Our Ref: 2015/241433

Your Ref: SSI-6622

**Submission on the Stage 2 EIS for the Northern Beaches Hospital Road Connectivity & Enhancement Works (SSI-6622)**

Modelled locations of the Stage 2 Project (DRAINS and MUSIC) Fig. 16-3

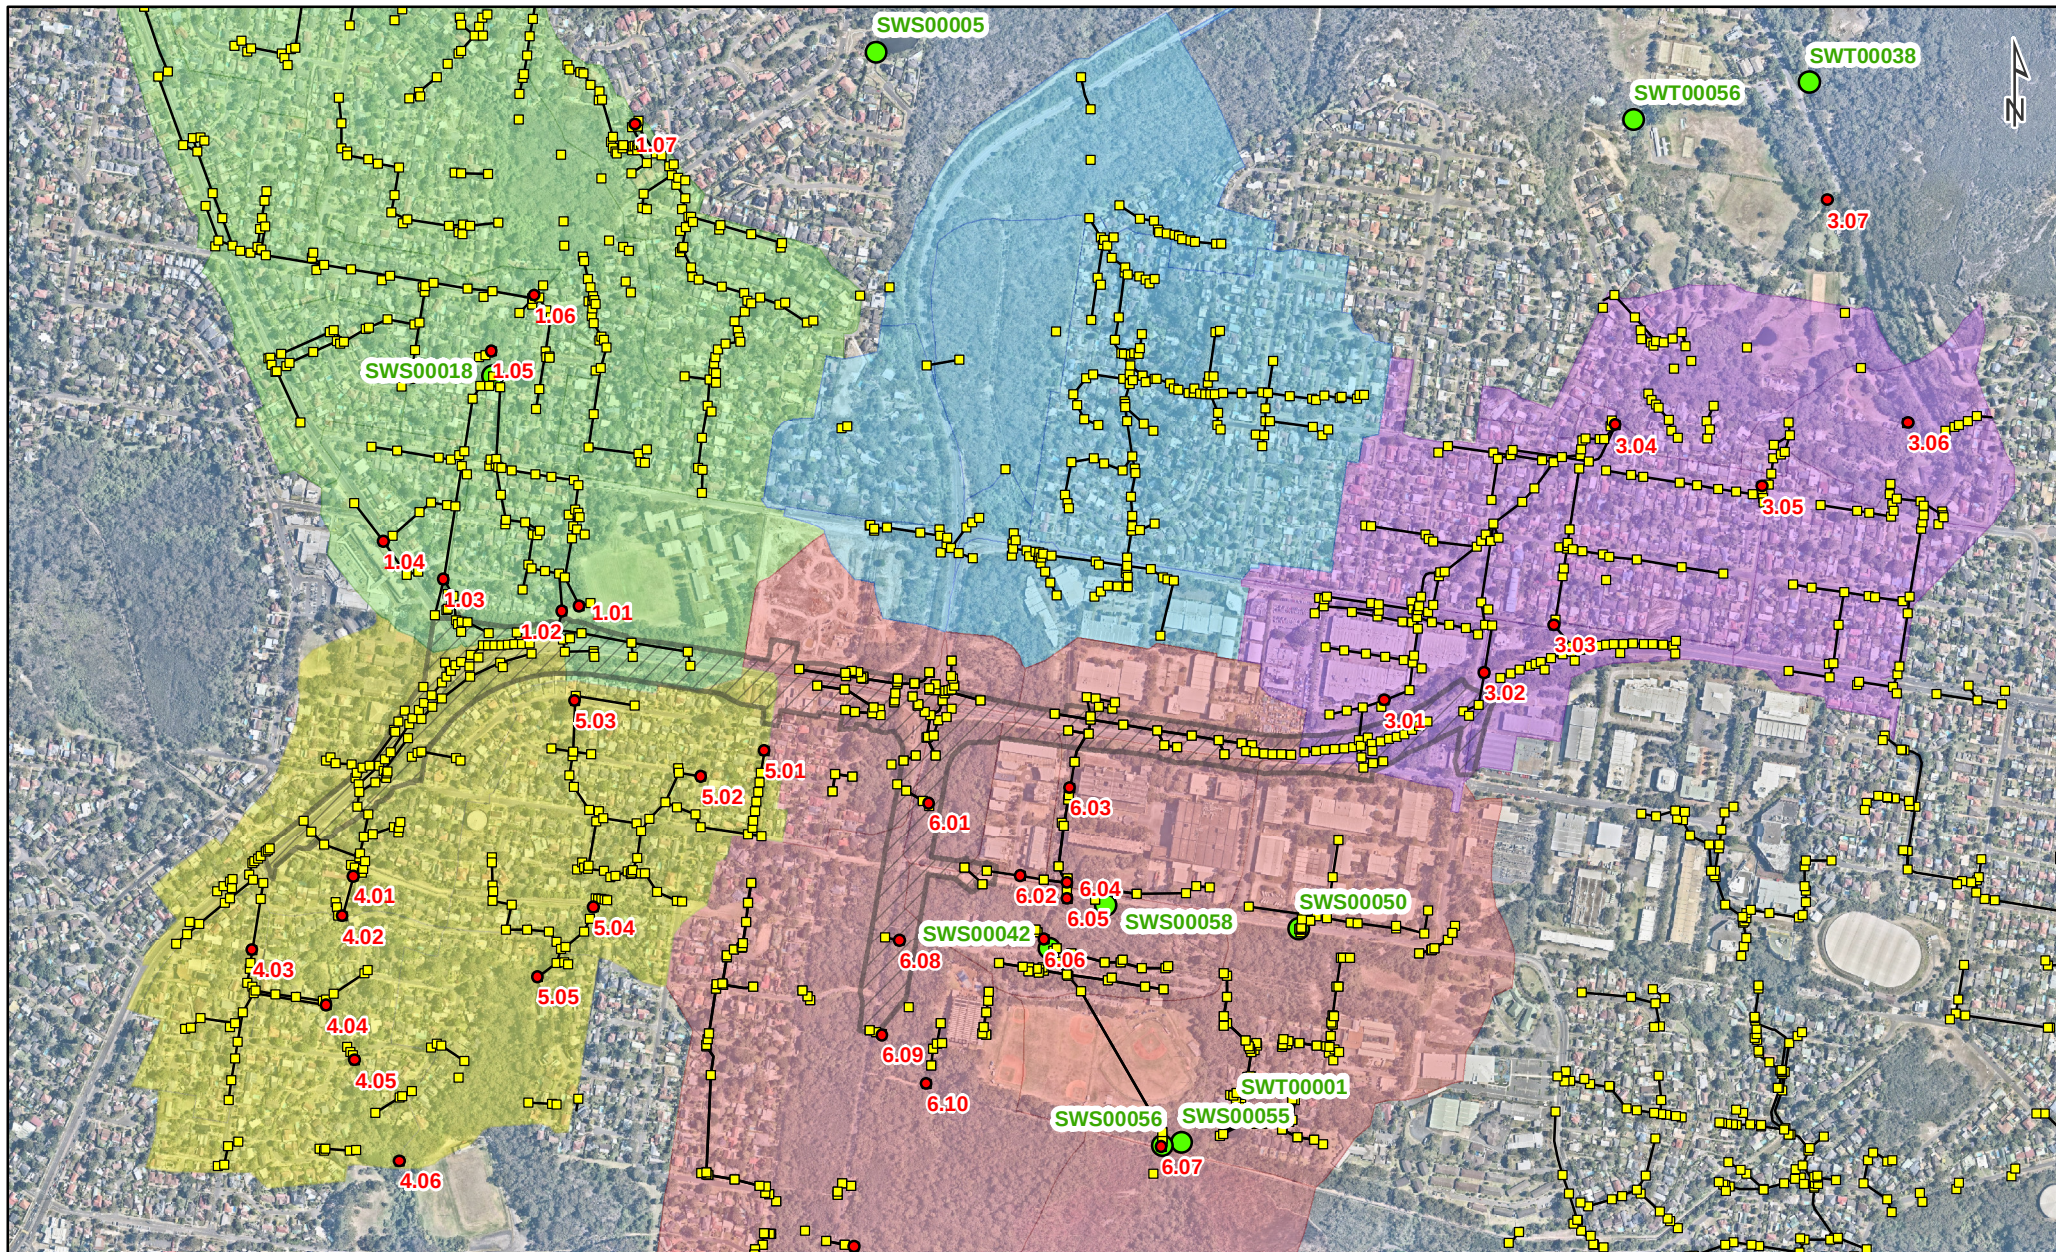
However the EIS notes a 13% simulated increase in nitrogen at 6.01 and up-gradient to 6.06 to Curl Curl Creek (pg.348, Chpt. 16, Vol. 1 & Appendix L – Surface Water Assessment). Assessment must be made as to whether to this falls outside of the adopted water quality objectives of TN - 0.250, Nox - 0.030 and NH<sub>4</sub><sup>+</sup> - 0.010. In addition, there has not been adequate consideration of groundwater inputs.
